Elpaso County Planning and Community Development

I have reviewed the AL2321 plan documents to find this use to be unacceptable within the RR5 zoning in Pine Hills.

MONUMENT GLAMPING SITE PLAN
16315 RICKENBACKER AVE.
MONUMENT, CO 80132

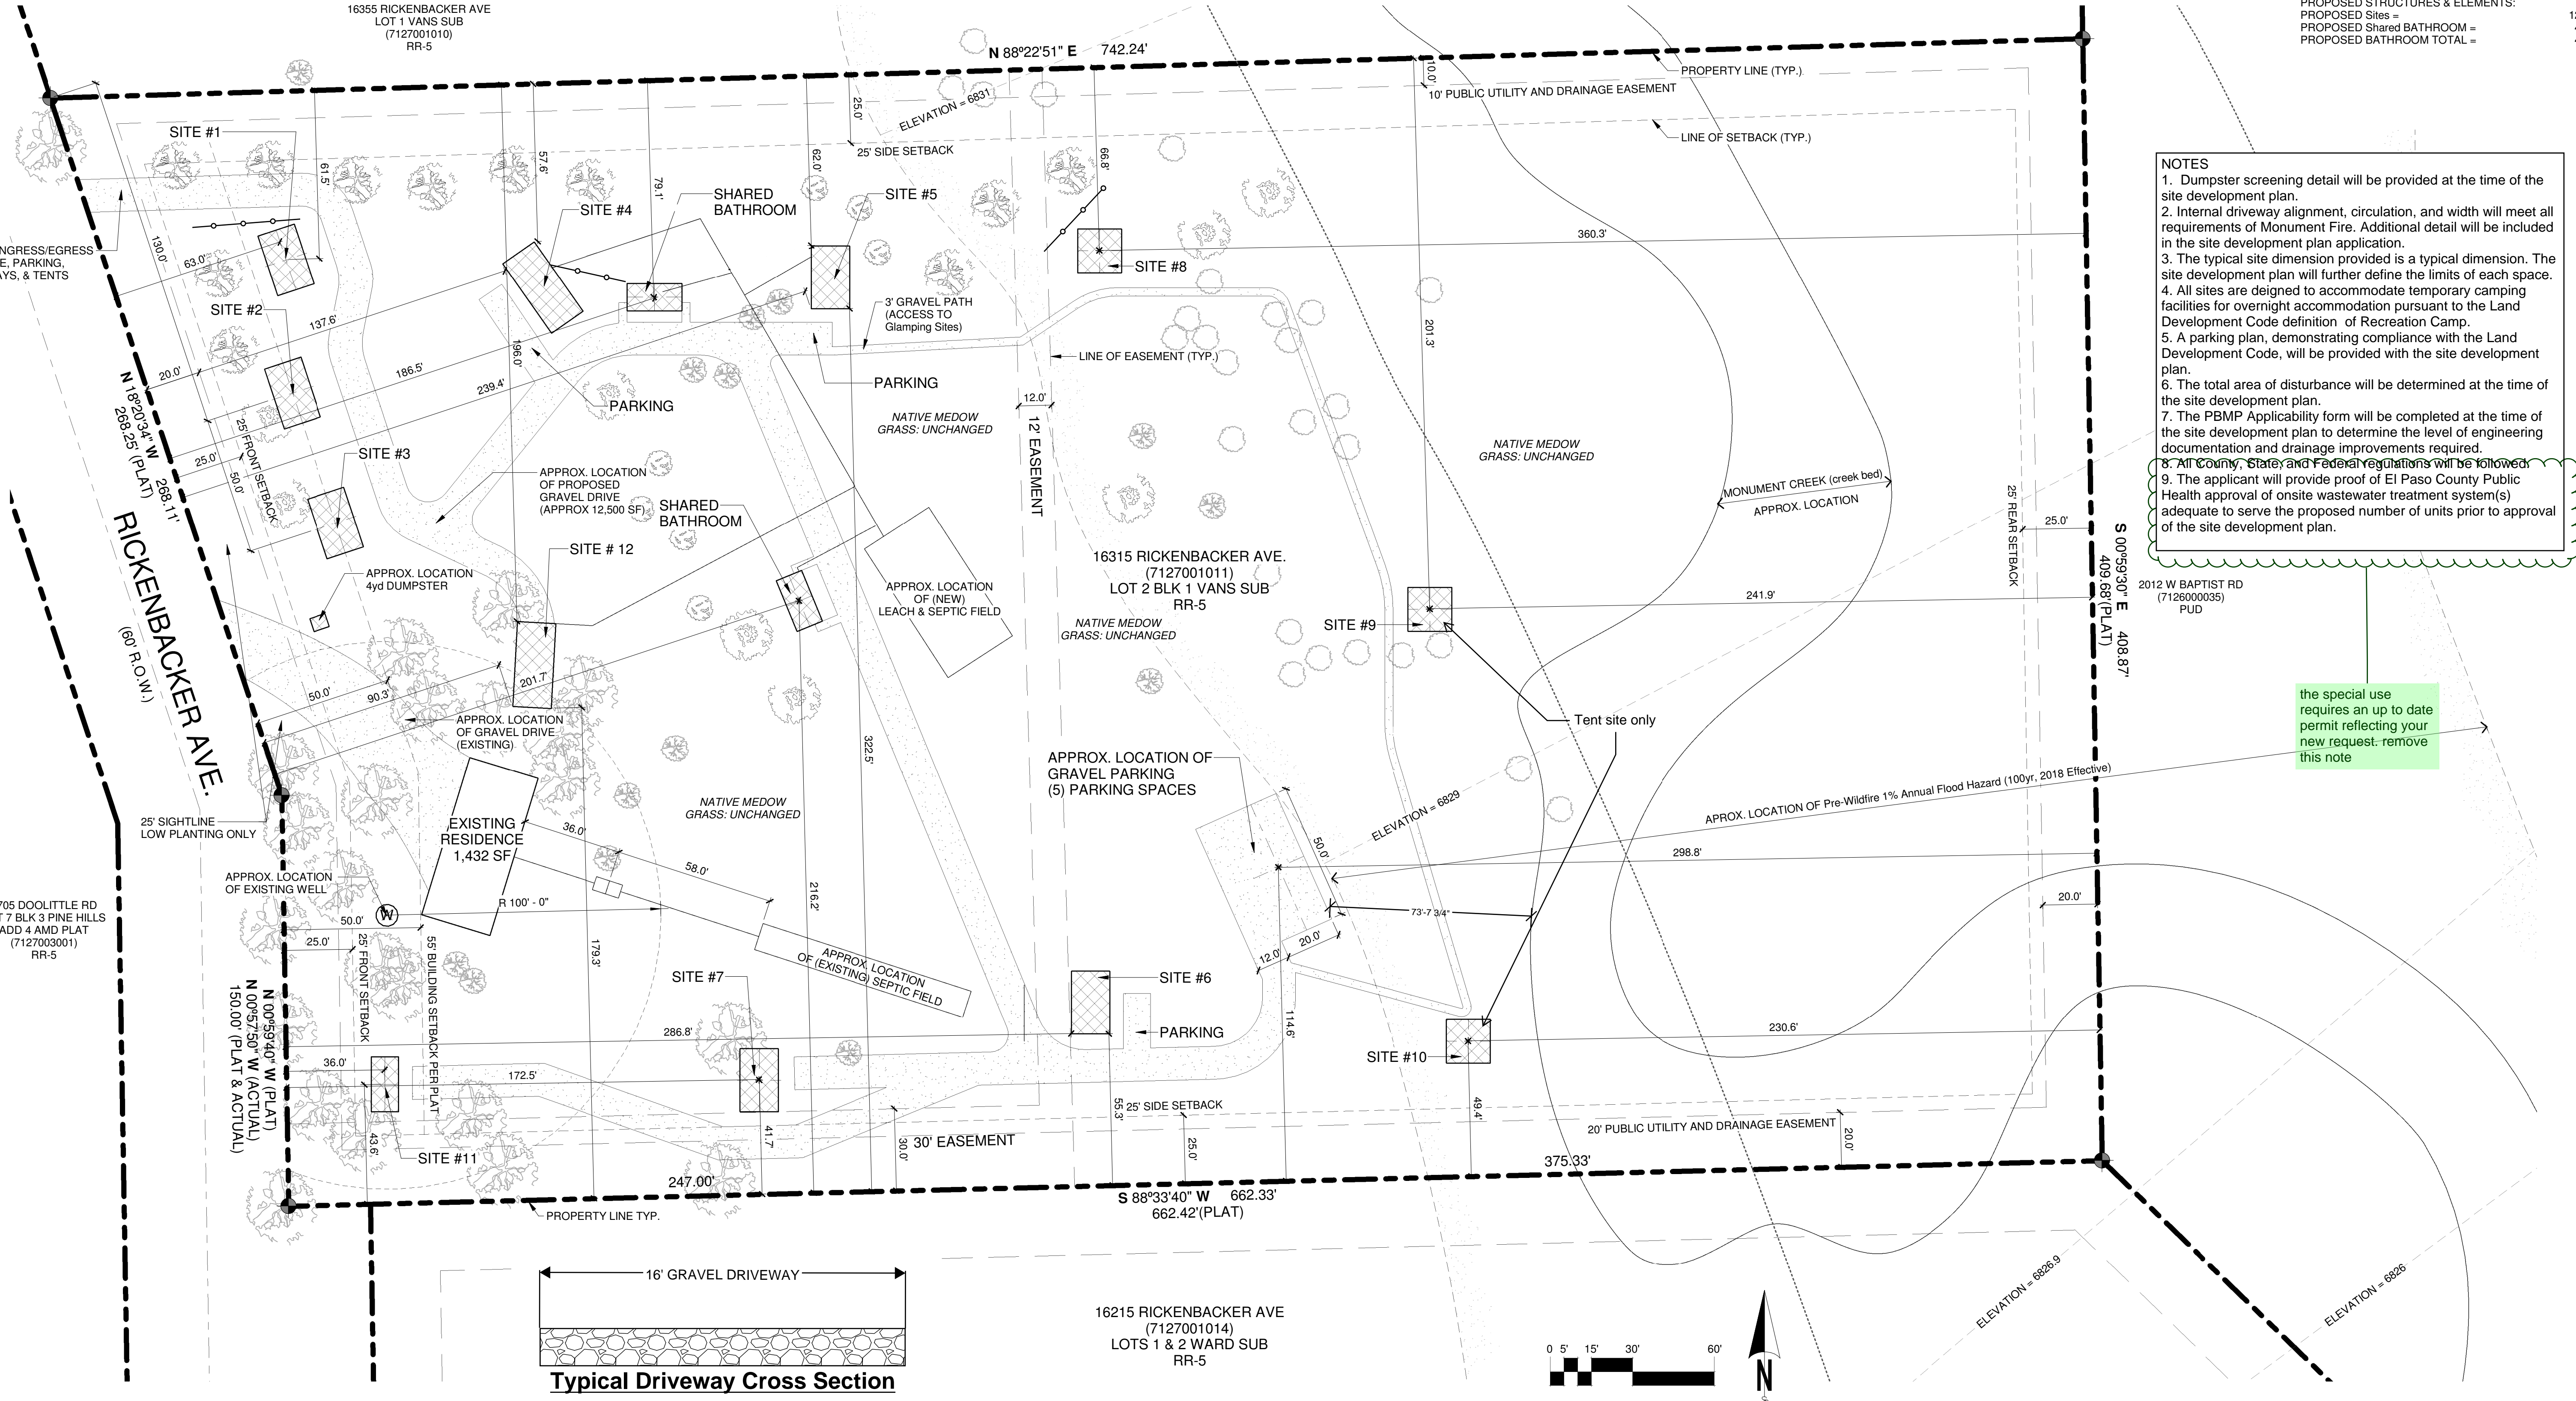
This area is zoned RR-5 and Agricultural ratings. This zoning does not include a camping business. Nor do I see access per the plan for emergency vehicles.

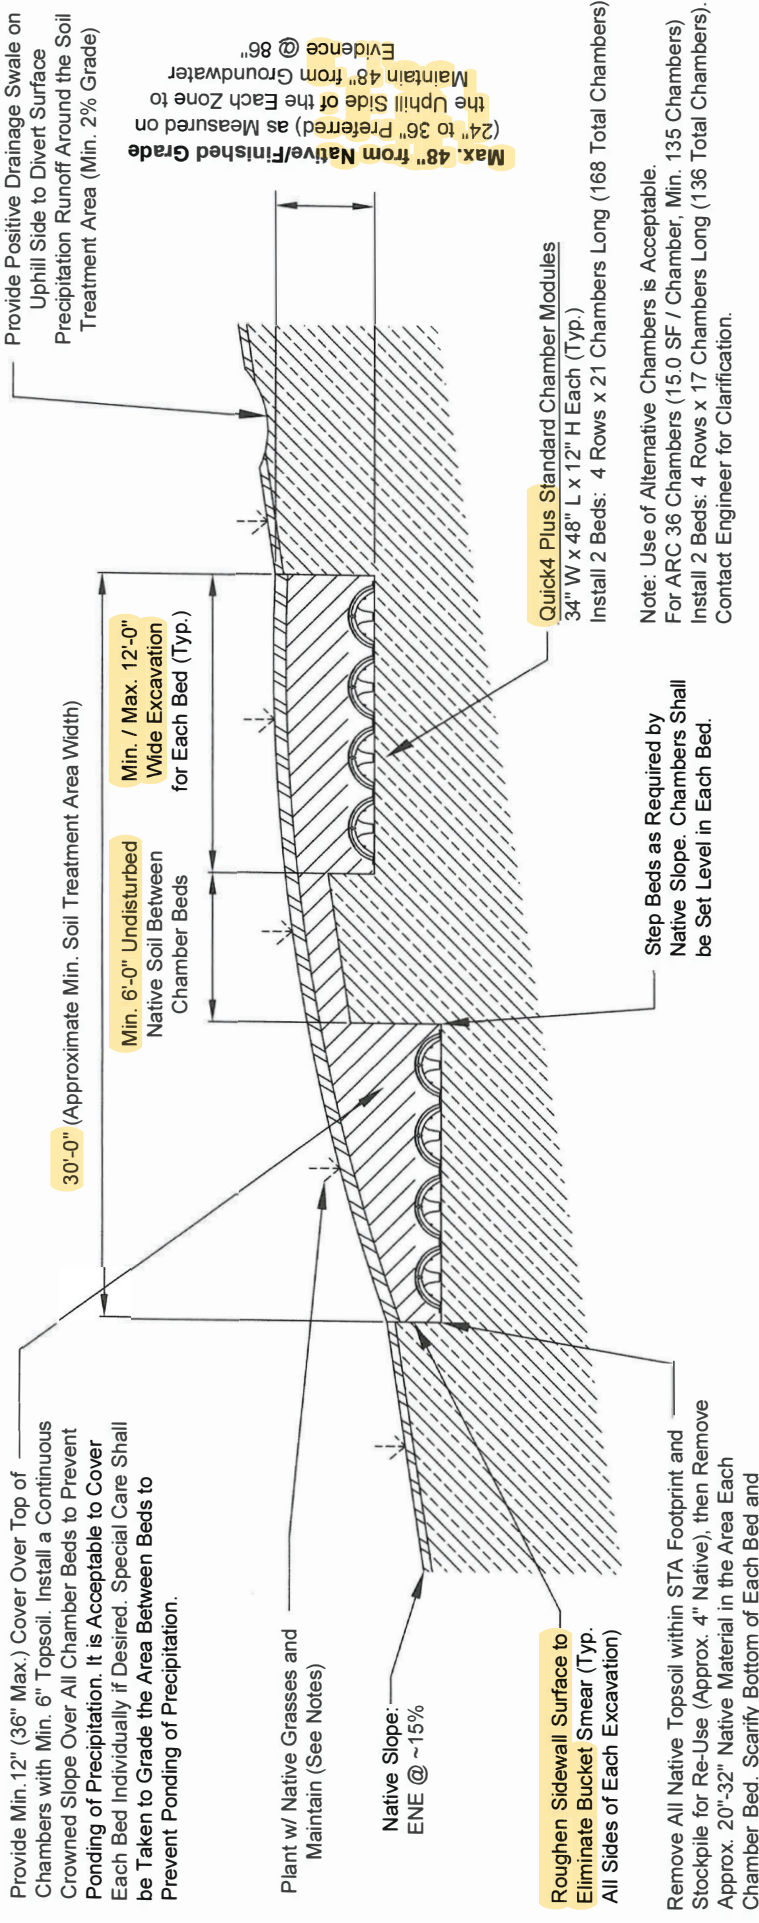
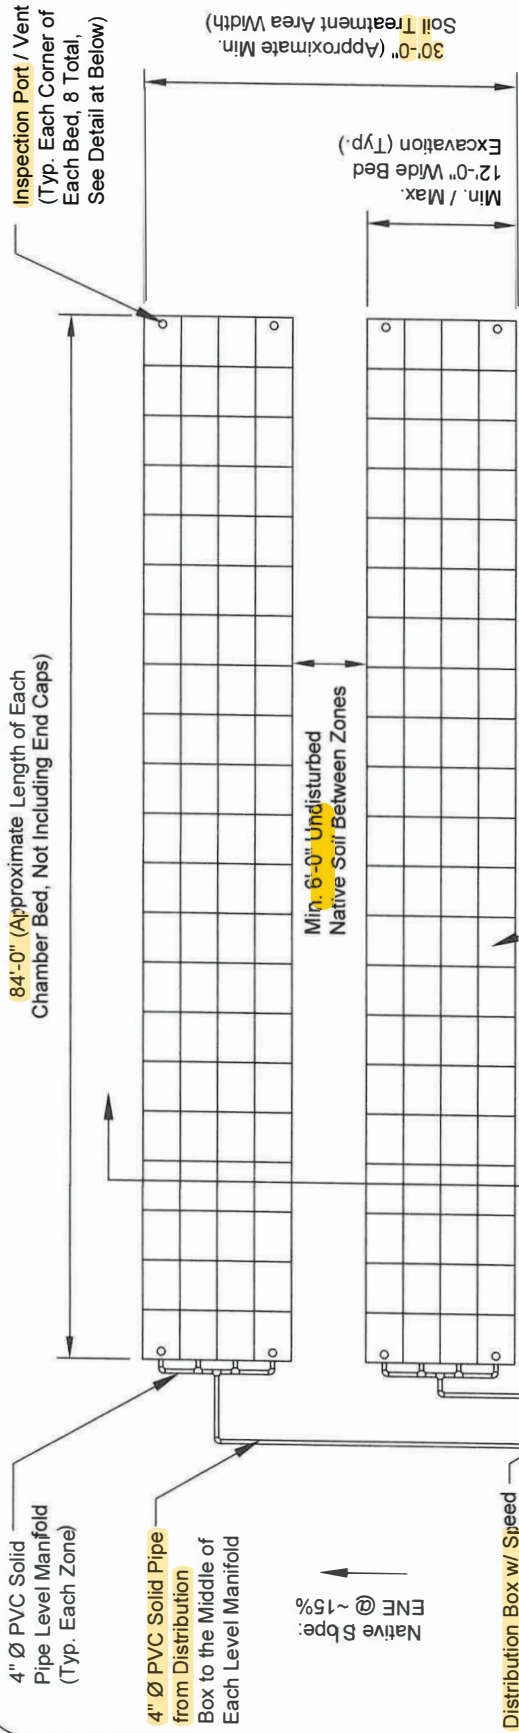
The amount of water and septic needs are more than a existing single family home and may impact the neighboring domestic wells. The amount of waste water 1200 gallons per day also exceeds the amount of a single family residence and may affect neighboring domestic water well quality.
